PLANNING CONSULTATION RESPONSE

Application No	2026/0322
Proposal	Erection of detached residential dwellinghouse
Address	24 Common Road, Brierley, Barnsley, S72 9ES
Date of Consultation Reply	21/05/26
Consultee	Highways DC

Consultation Assessment and Justification

PROPOSED SITE PLAN
SCALE 1:250

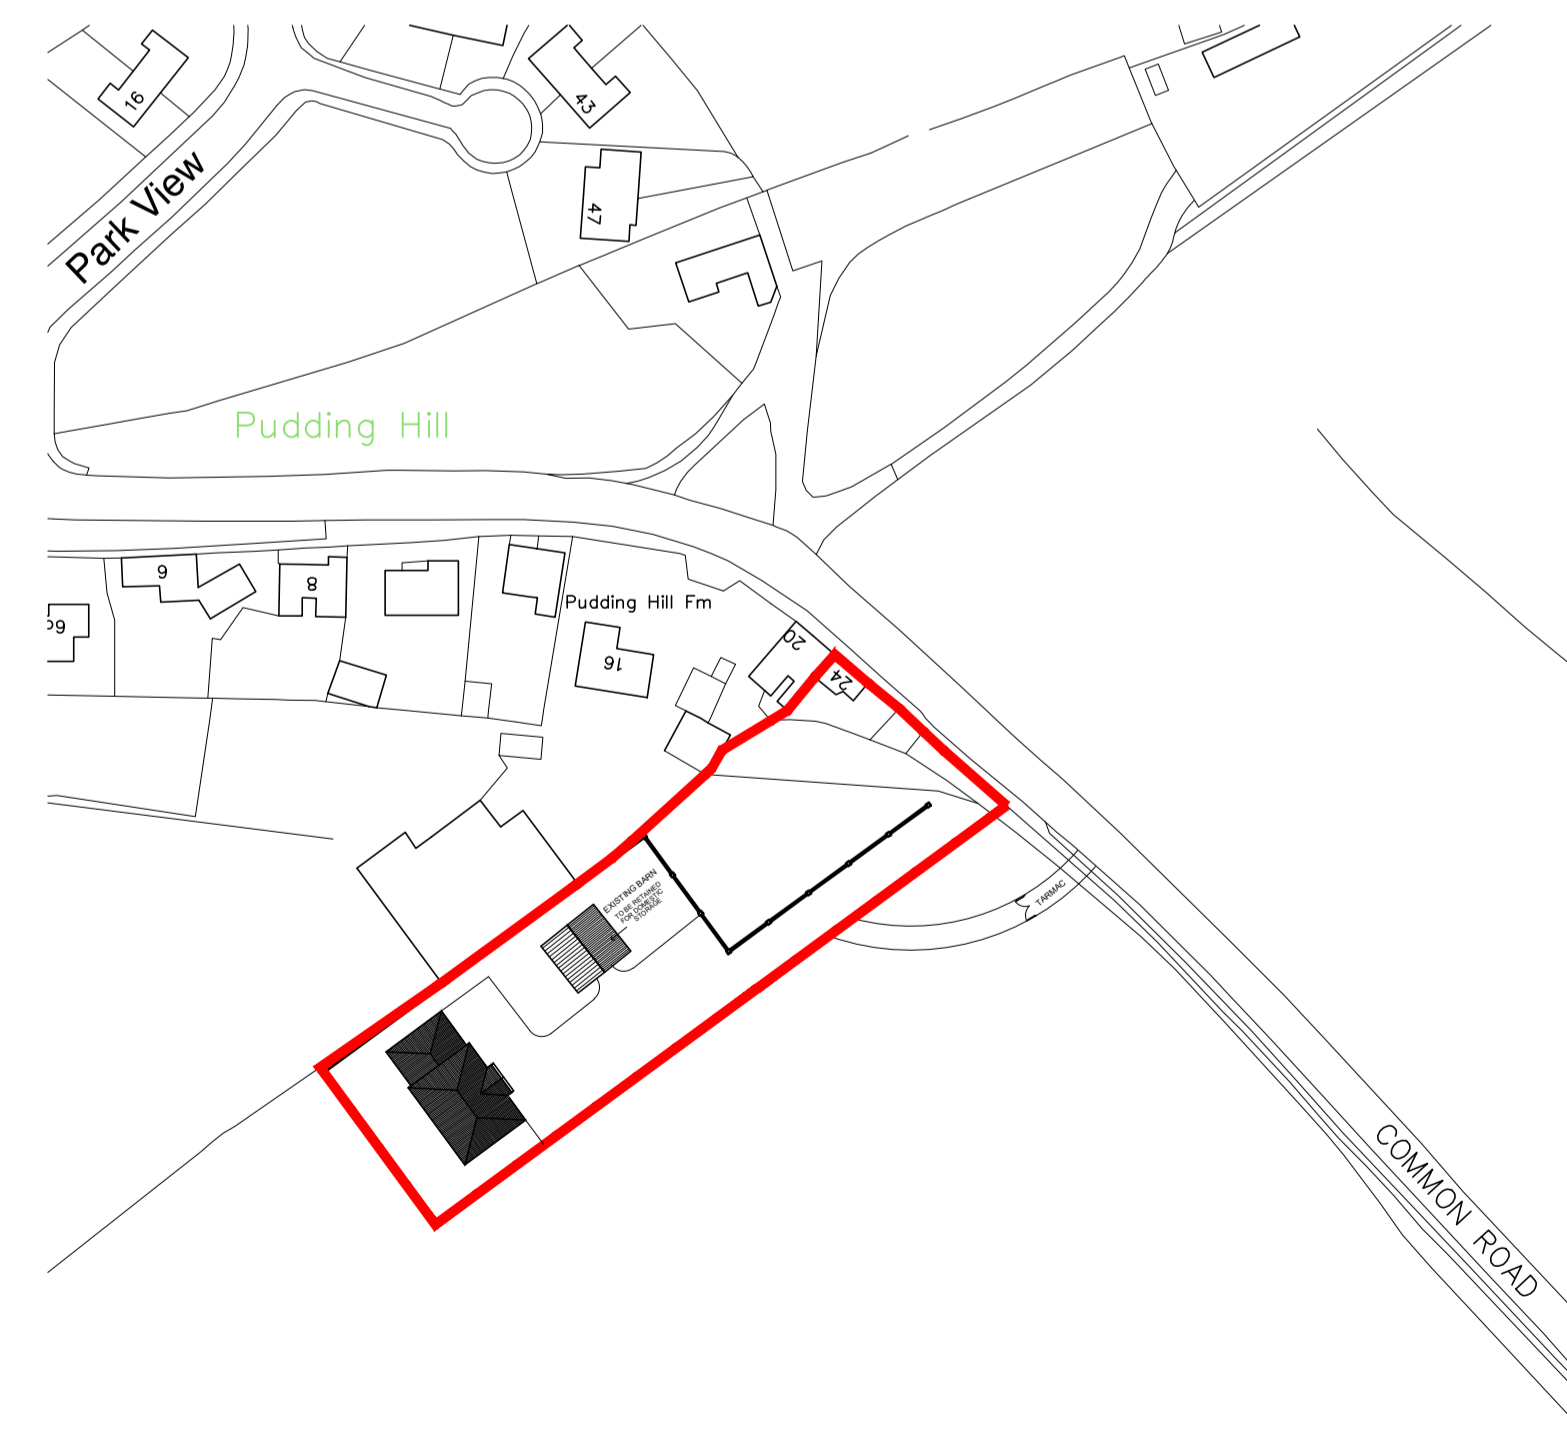
However, the built access does not reflect the approved drawings of either previous permission; as such, HDC officers would ask that the visibility splays from the access onto Common Road are demonstrated on a plan to be commensurate with the measured driven speeds ascertained by way of an independent speed survey. This is to ensure that the proposals can provide safe egress from the site onto the public highway as per the advice given in Section 7.5 of Manual for Streets.

Fire Safety: Approved Document B states that access for a pumping appliance should be provided to within 45m of all points inside the property; dead-end routes longer than 20m also require turning facilities. As the proposed dwelling is approximately 90m from the highway, swept path analysis is required of a fire appliance entering and exiting the site in a forward gear.

A refuse collection pad adjacent to the public highway should also be shown on the layout drawing.
